CIVIL ENGINEERING INFRASTRUCTURE REPORT

**STRATEGIC HOUSING DEVELOPMENT AT
ST. JOSEPH'S HOUSE AND ADJOINING PROPERTIES,
LEOPARDSTOWN**

CIVIL ENGINEERING INFRASTRUCTURE
REPORT FOR PLANNING

19.236-IR-01

| DRAWING No: BPR-BMD-00-ZZ-DR-C-1206 | ISSUE: PL6 |

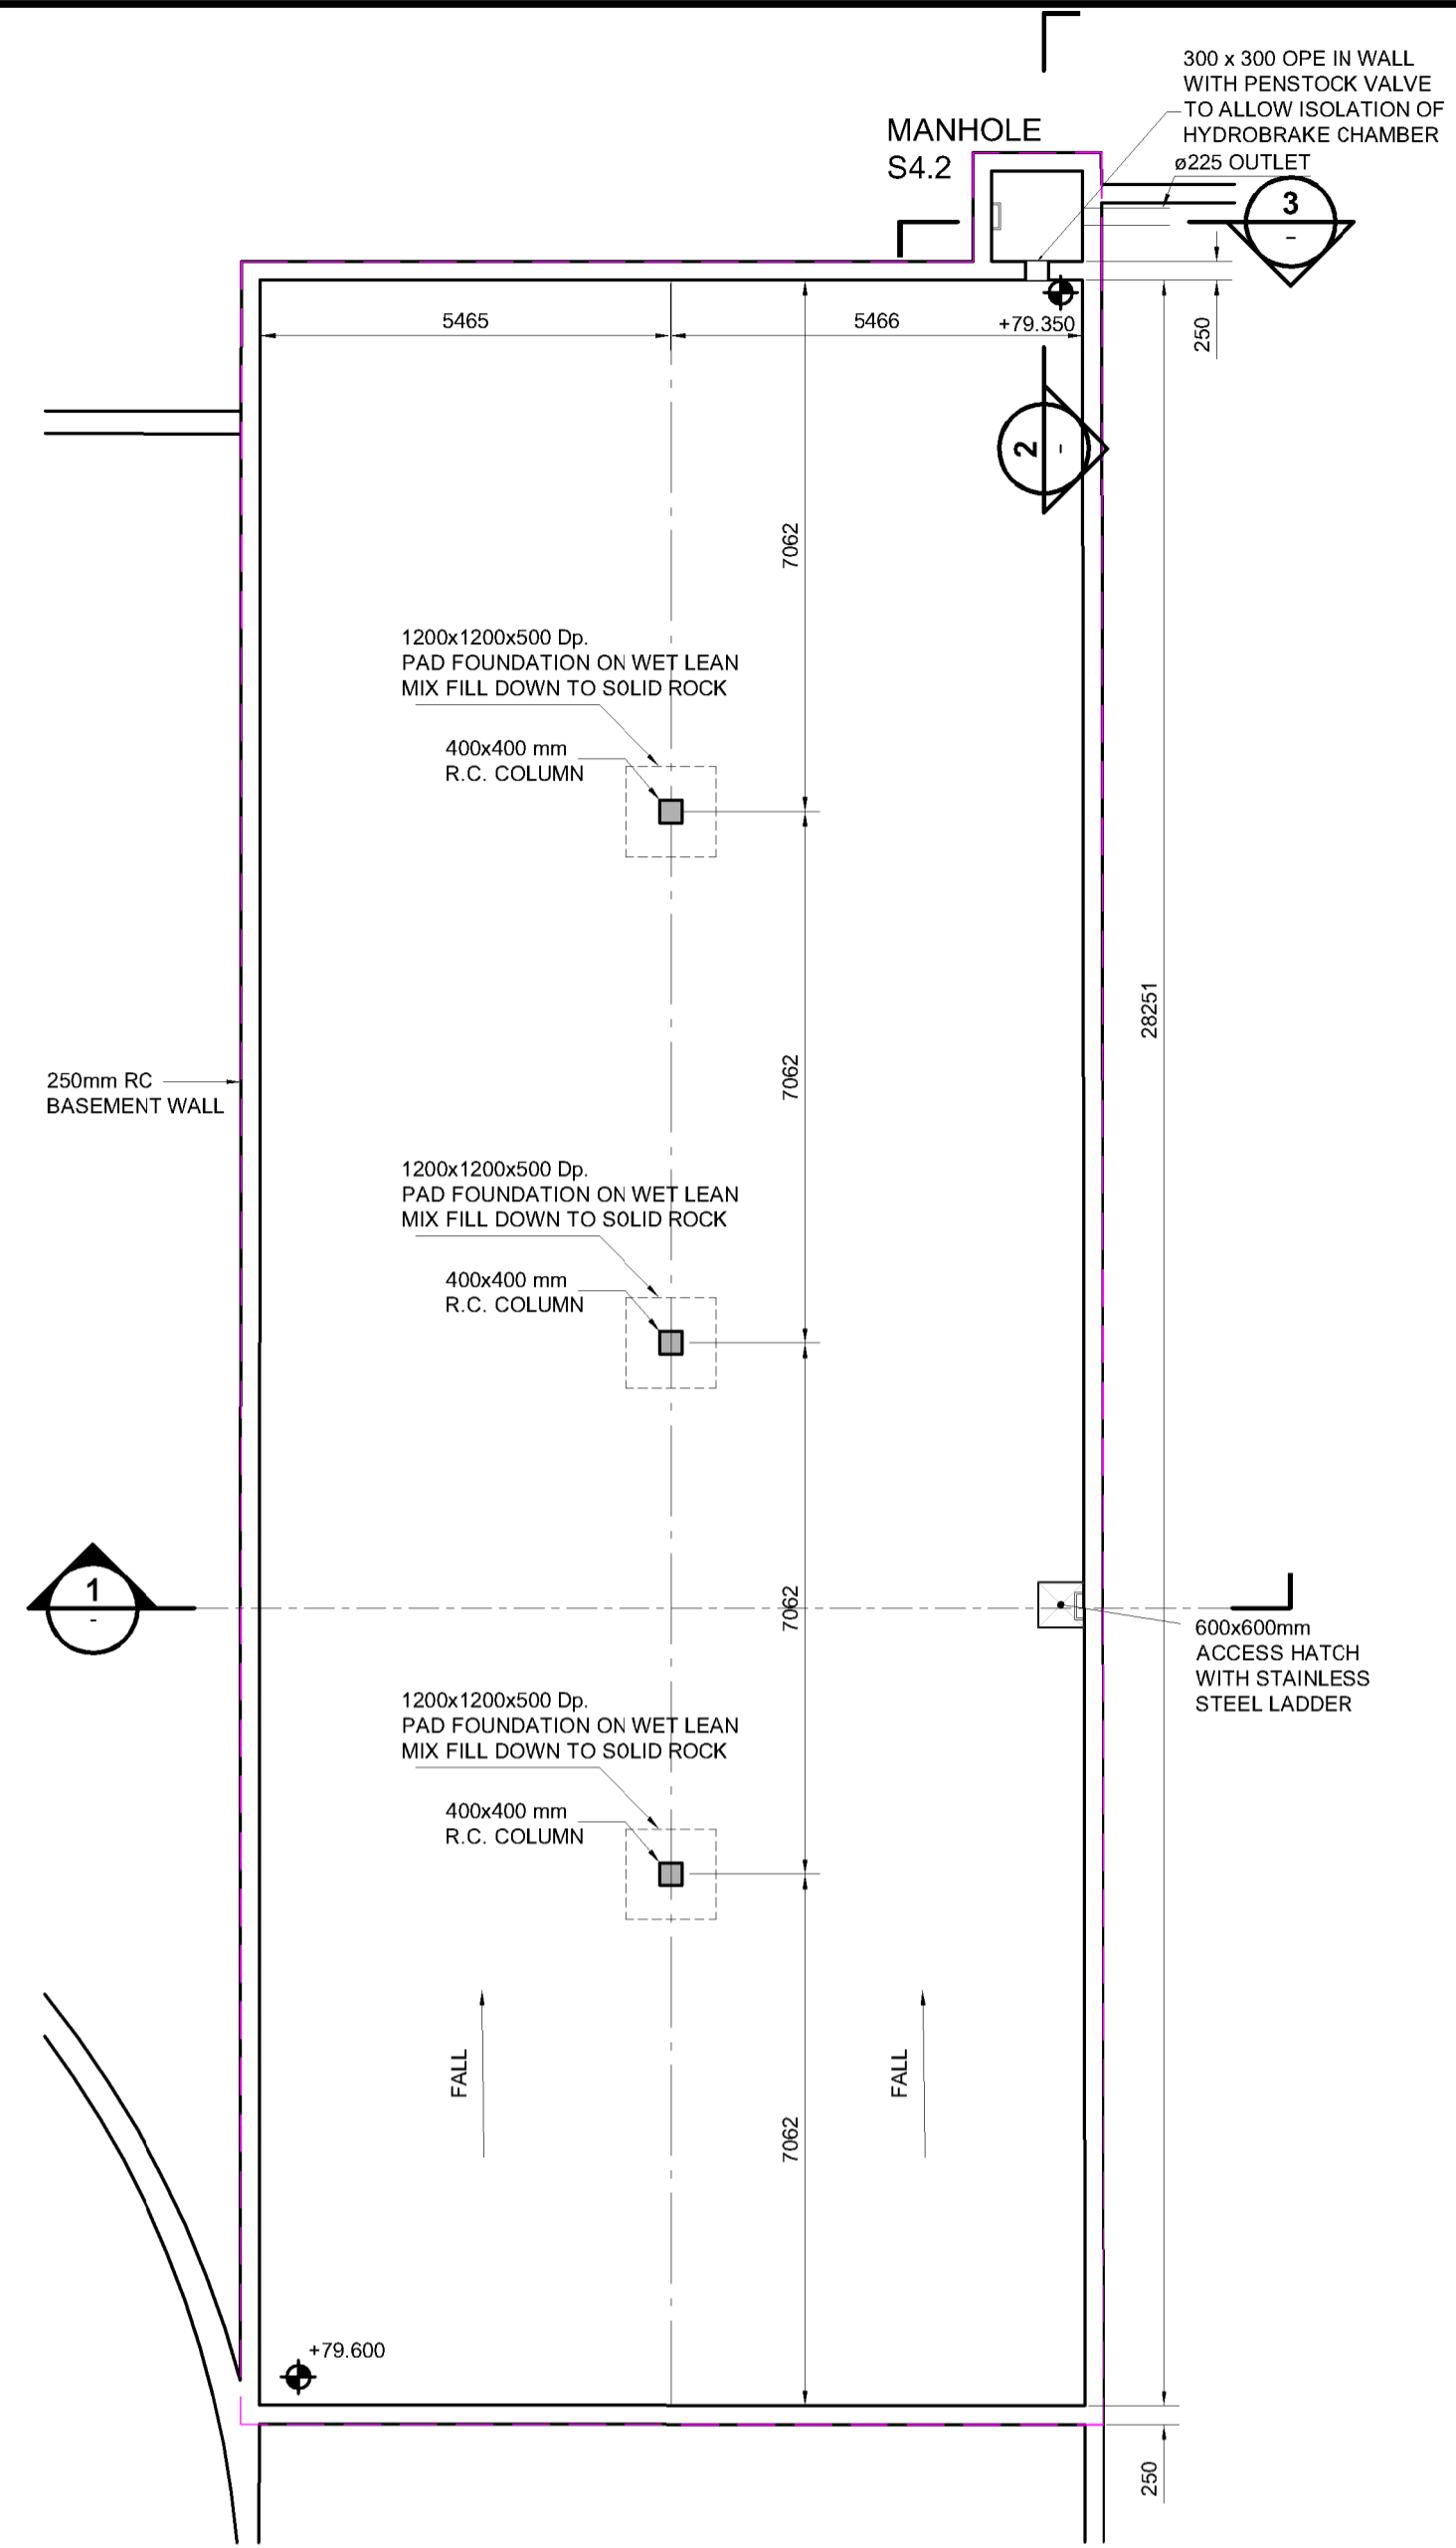
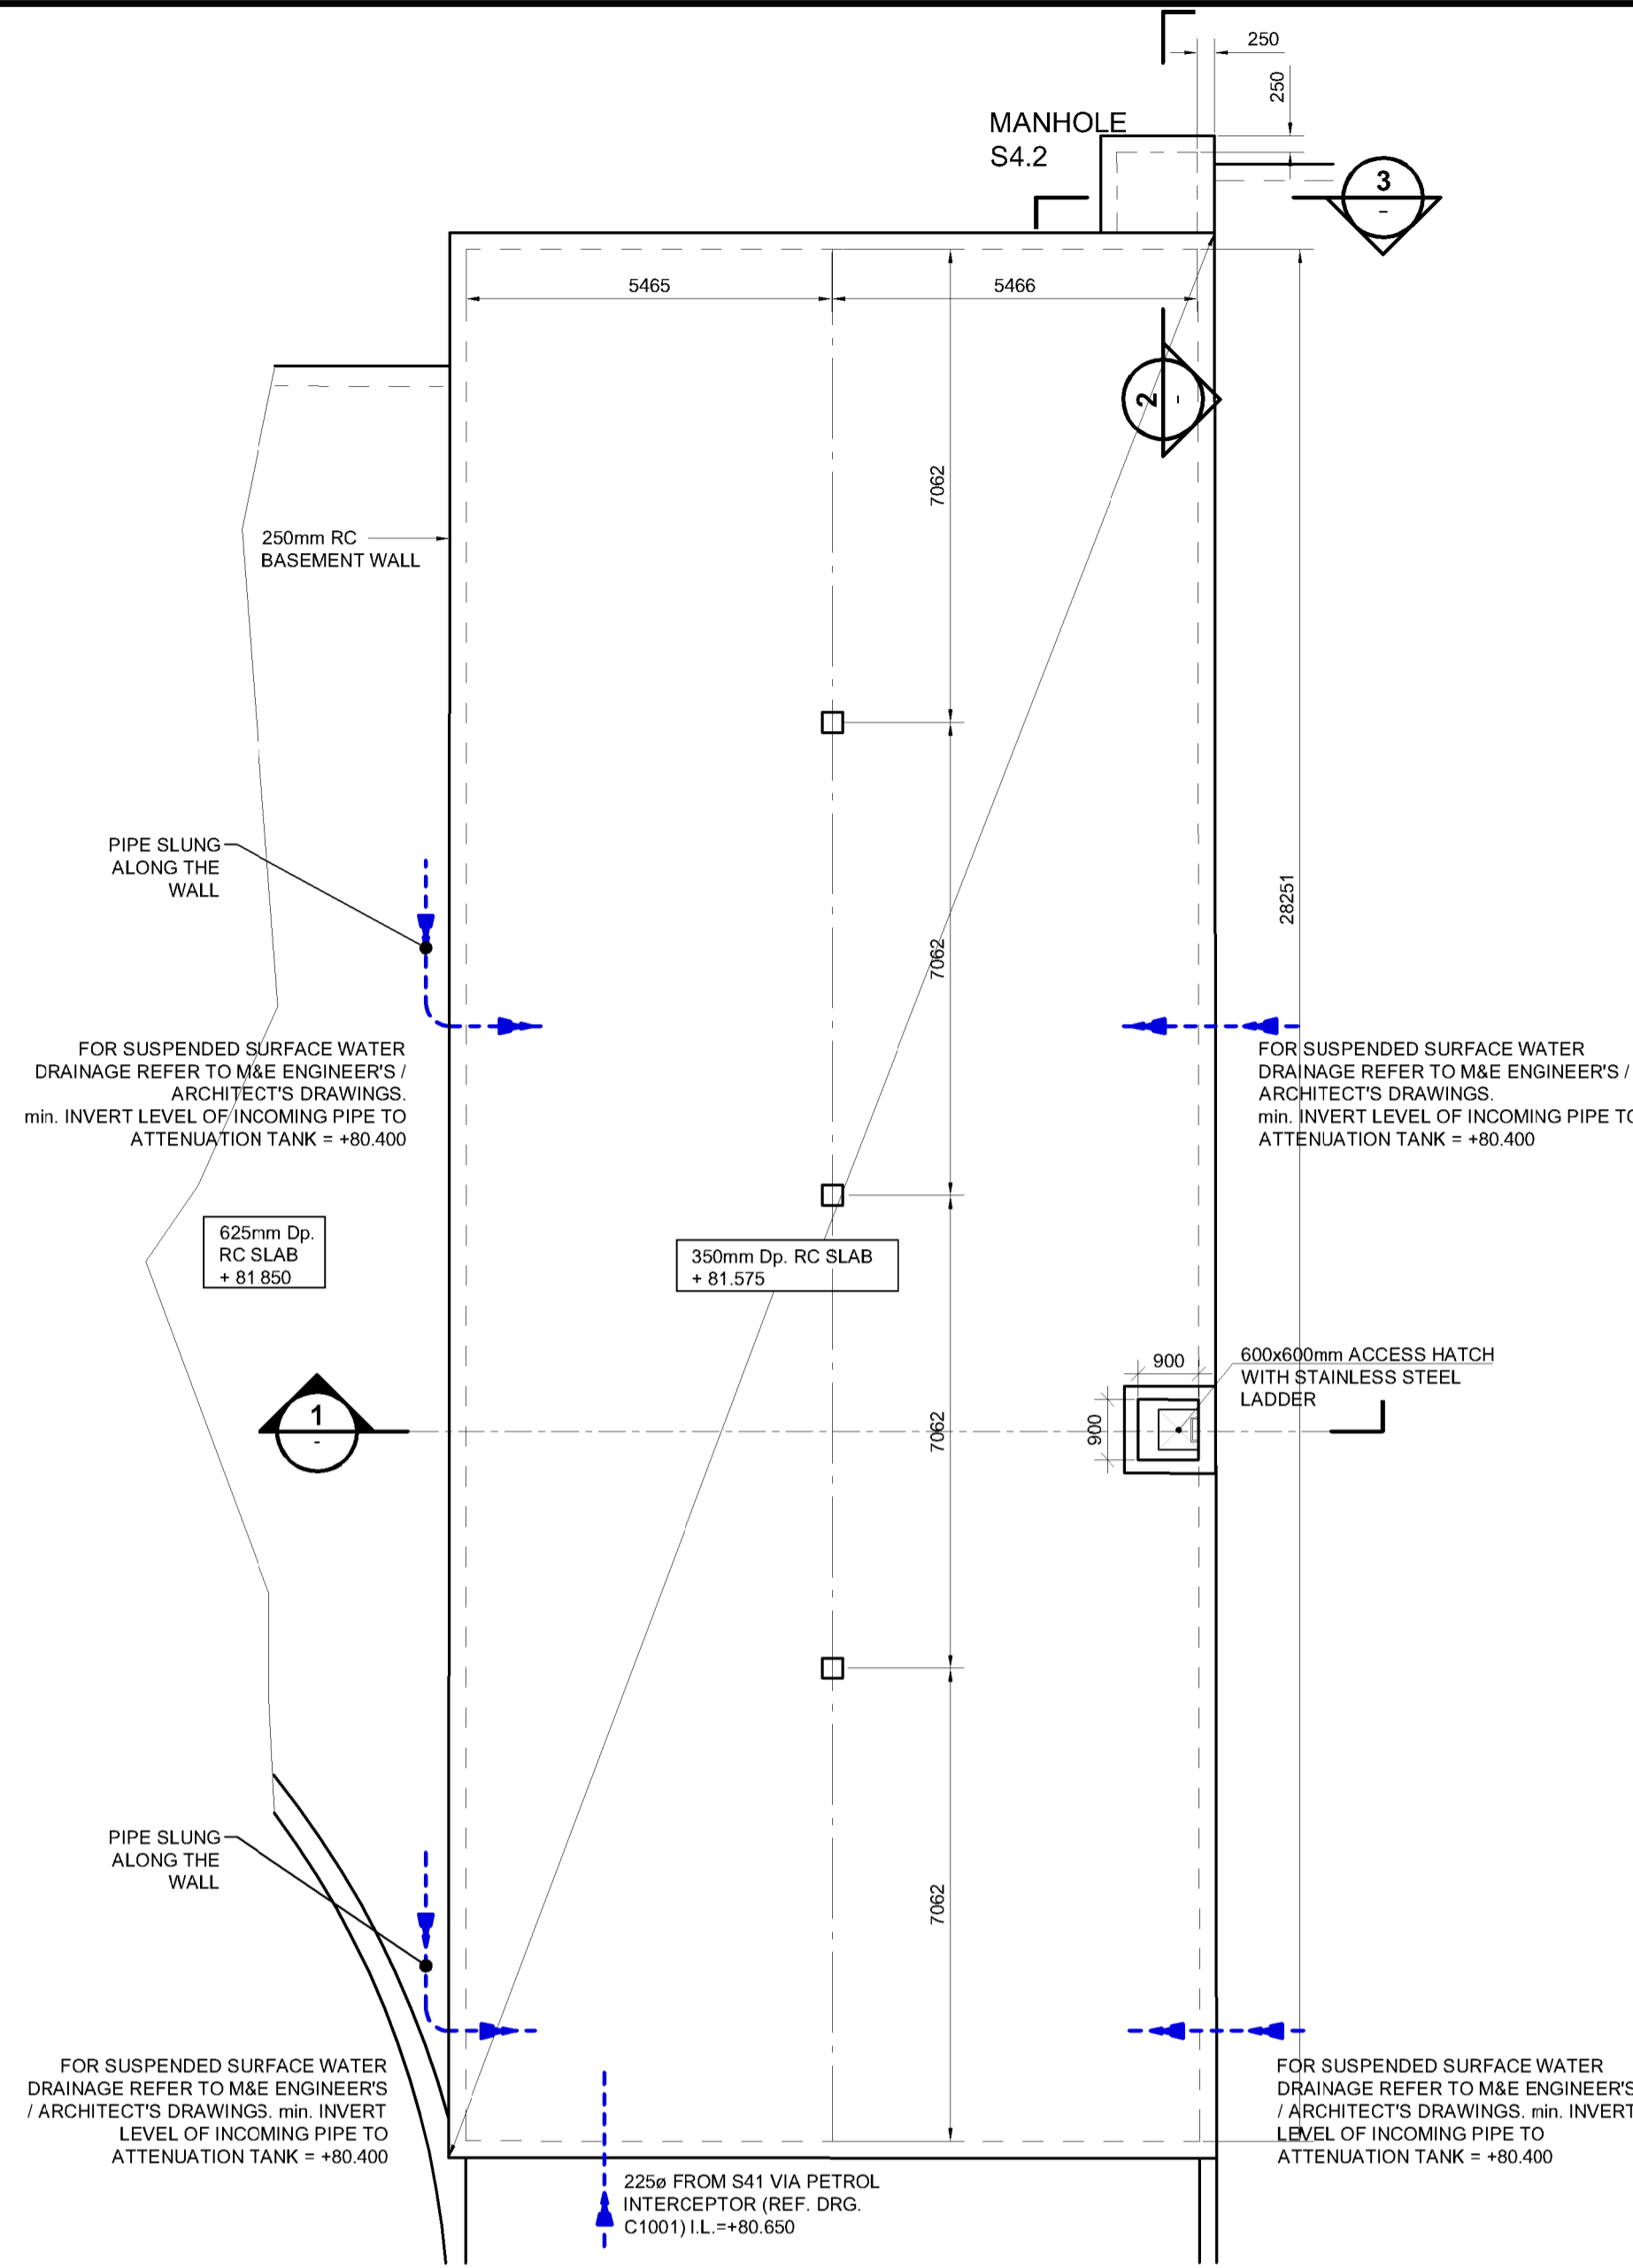
8. *As standard, the applicant is required to demonstrate by calculation in the report and by representation on a drawing that the proposed green roof extents are in accordance with the Council's Green Roof Policy such that the minimum coverage requirement of 60% is achieved. The applicant shall also provide details of maintenance access to the green roofs and should note that, in the absence of a stairwell type access to the roof, provision should be made for alternative maintenance and access arrangements such as external mobile access that will be centrally managed. The applicant should comment on the compatibility of the green roof with PV panels if they are to be incorporated into the design.*

BMCE: See Section 2.3.11 which outlines full roof availability and estimated coverage well in excess of 60% green roof proposed on new buildings. Also refer to C1005 for the proposed green roof locations. Please see the architectural drawings for access details to the roof areas. All

maintenance access to green roofs will be accessed from AOVs within top storey stair core, with the exception of the roof of the 4 storey element of Block B, can be accessed by a hatch in the corridor. PV panels are not proposed on this project.
